From: Nicola Swann [REDACTED]
Sent: 30 June 2021 10:18
To: Planning.Responses <Planning.Responses@arun.gov.uk>
Subject: Pagham responses

P/132/20/RES & P/79/21/RES – the Council wishes to OBJECT to these applications. Please see attached comments.

P/84/21/DOC Approval of details reserved by condition imposed under ref W/4001476 (P/58/19/PL) relating to Condition Nos 5 - Construction & Environmental Management Plan, 6 - surface water drainage, 7 - maintenance & management of surface water drainage, 8 - badger survey and 9 level survey. Land to the rear of Inglenook Hotel. The Council wished to OBJECT to the application. The comments of the

Drawing Status	FOR APPROVAL						
Client	Future Group Development Ltd						
Project	Land at The Inglenook Pagham Road, Bognor Regis PO21 3QB						
Drawing Title	Proposed Drainage Arrangement Sheet 2 of 2						
Scale	1:200	Date	May 2021	Drawn By	DJL	Checked By	MJA
Drawing No.	D1966-103.2	Rev.	-

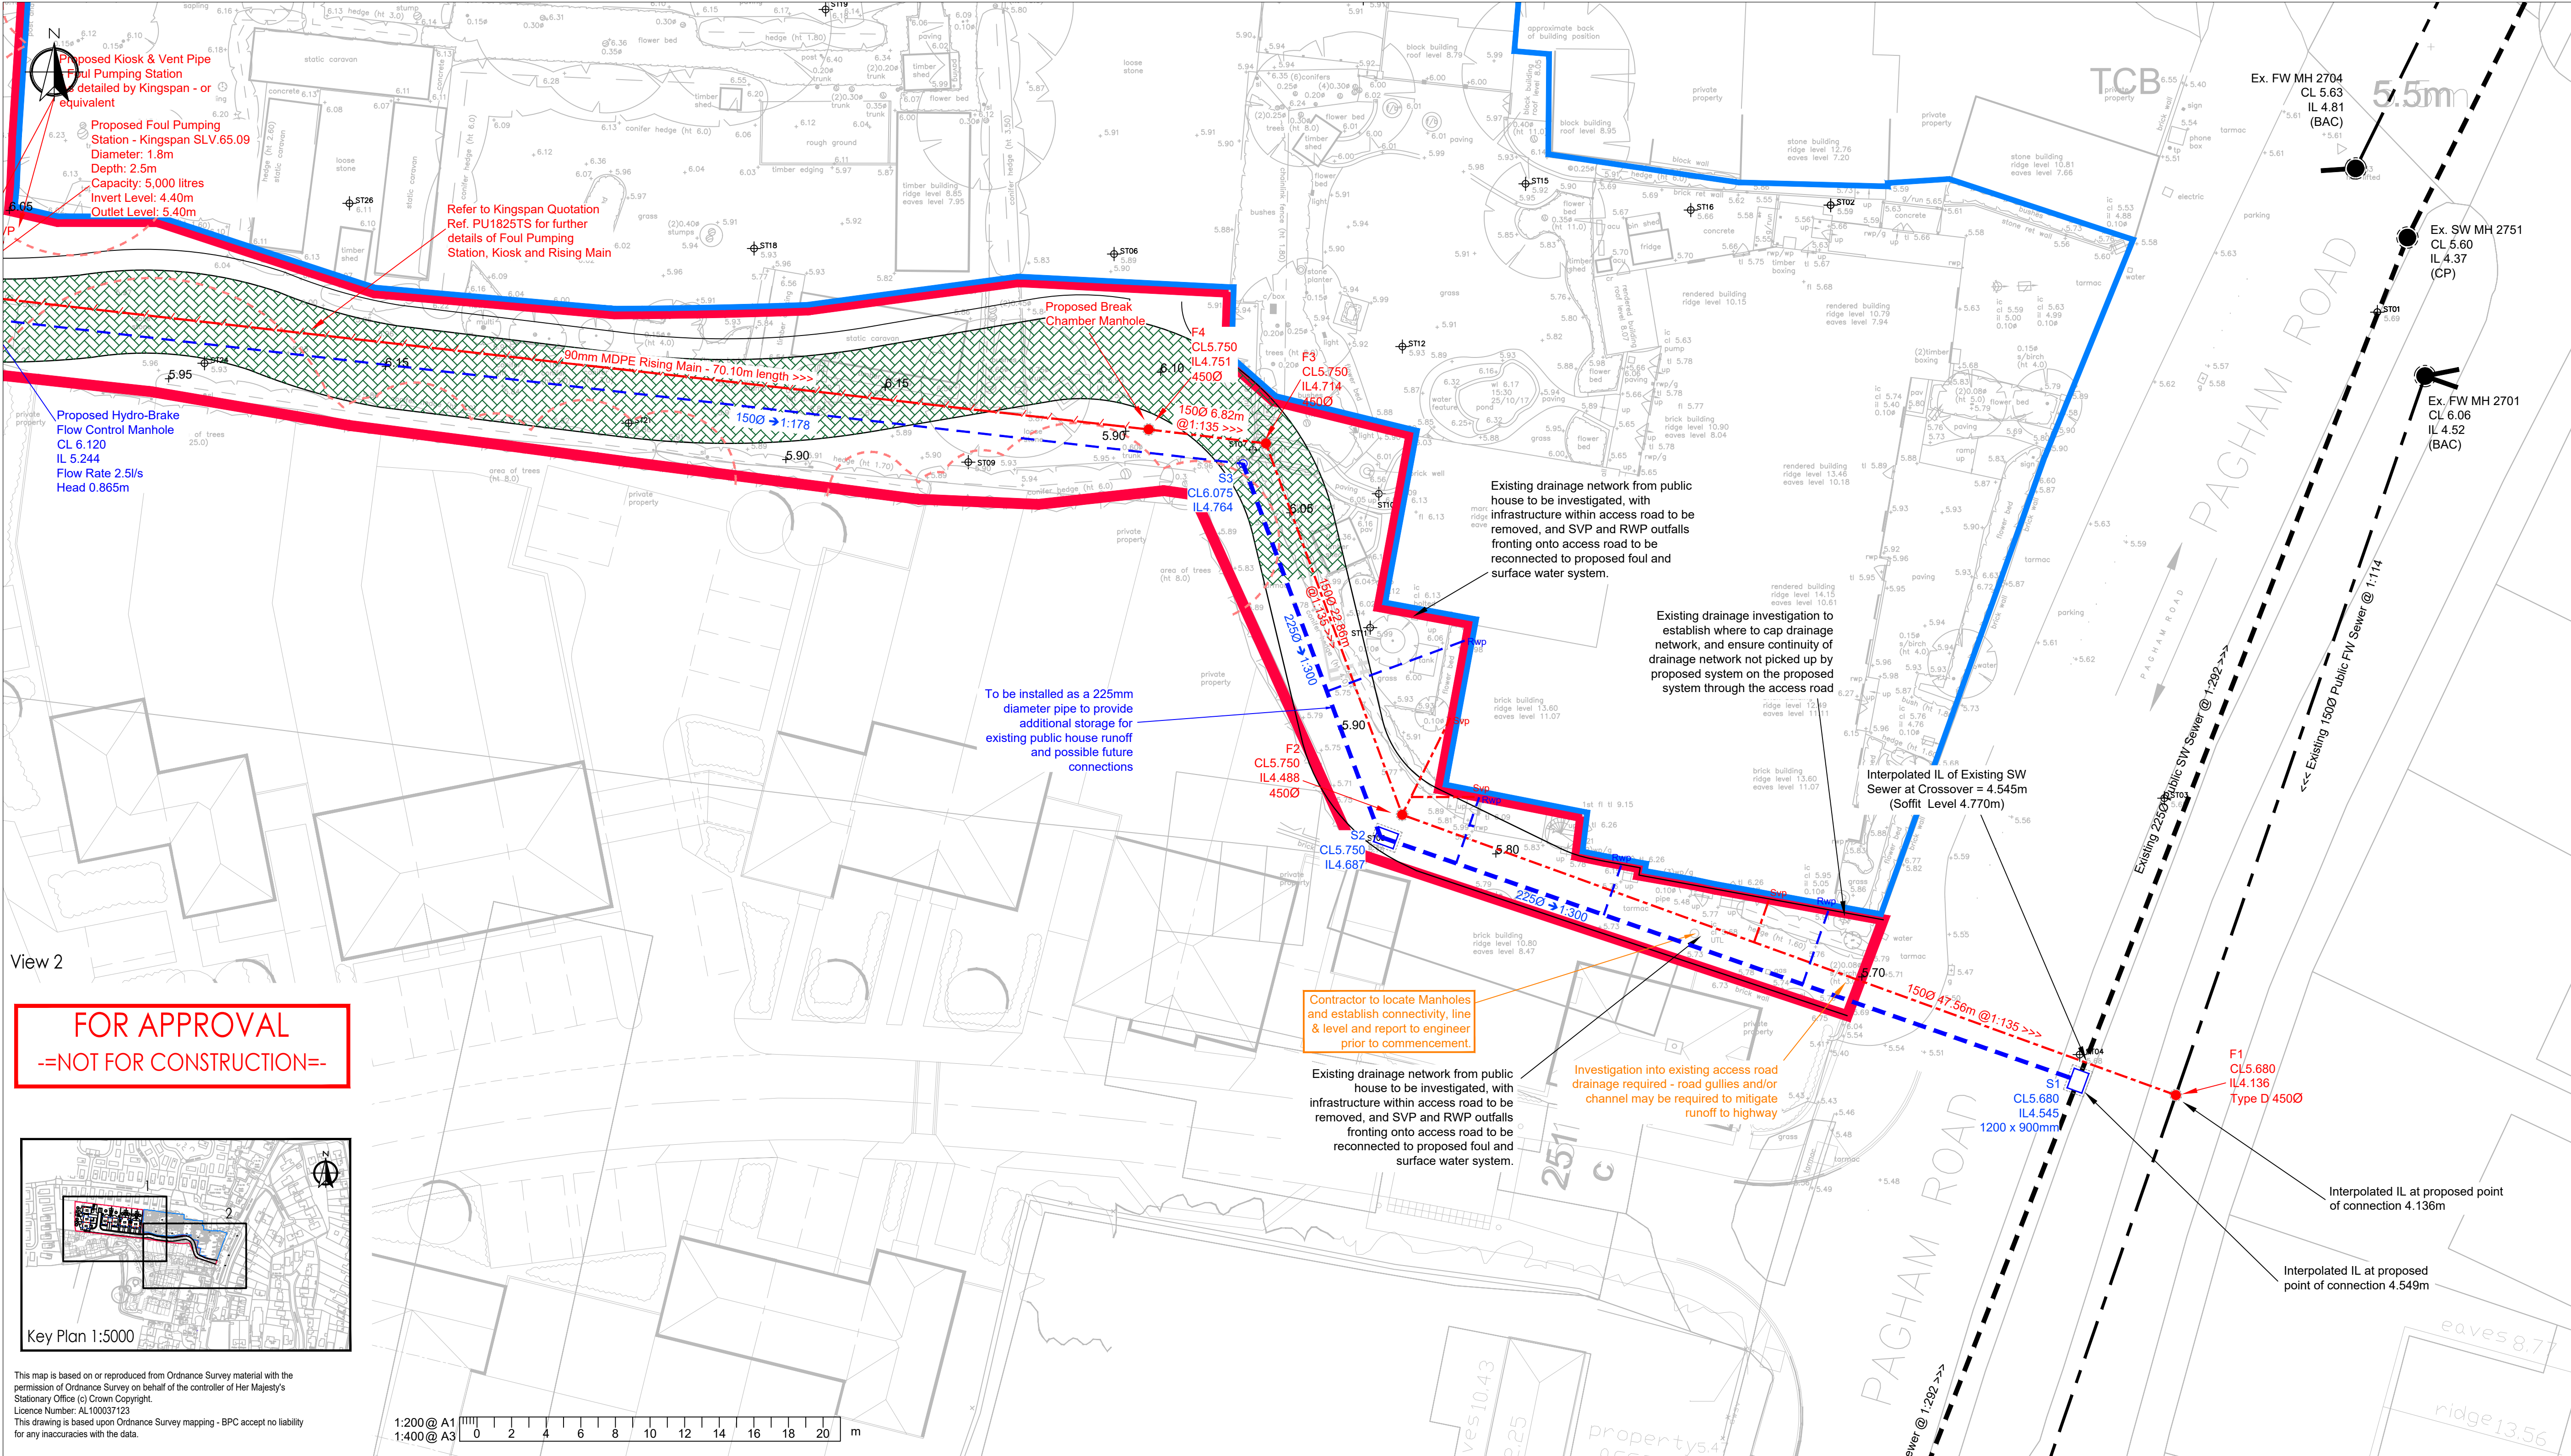
The Council believes the drainage strategy to be unsustainable. The waste water treatment works is already at capacity without the addition of these properties. Of equal concern is the surface water strategy. Permeable paving may not work in the winter months. There are established problems with the drainage in the area, and the Council has been working with ADC officer Paul Cann regarding resolving these problems. The Council asks that he is consulted regarding the proposals as his specialist knowledge of the problems currently being experienced in Pagham will be vital in ensuring the drainage scheme works given local conditions.
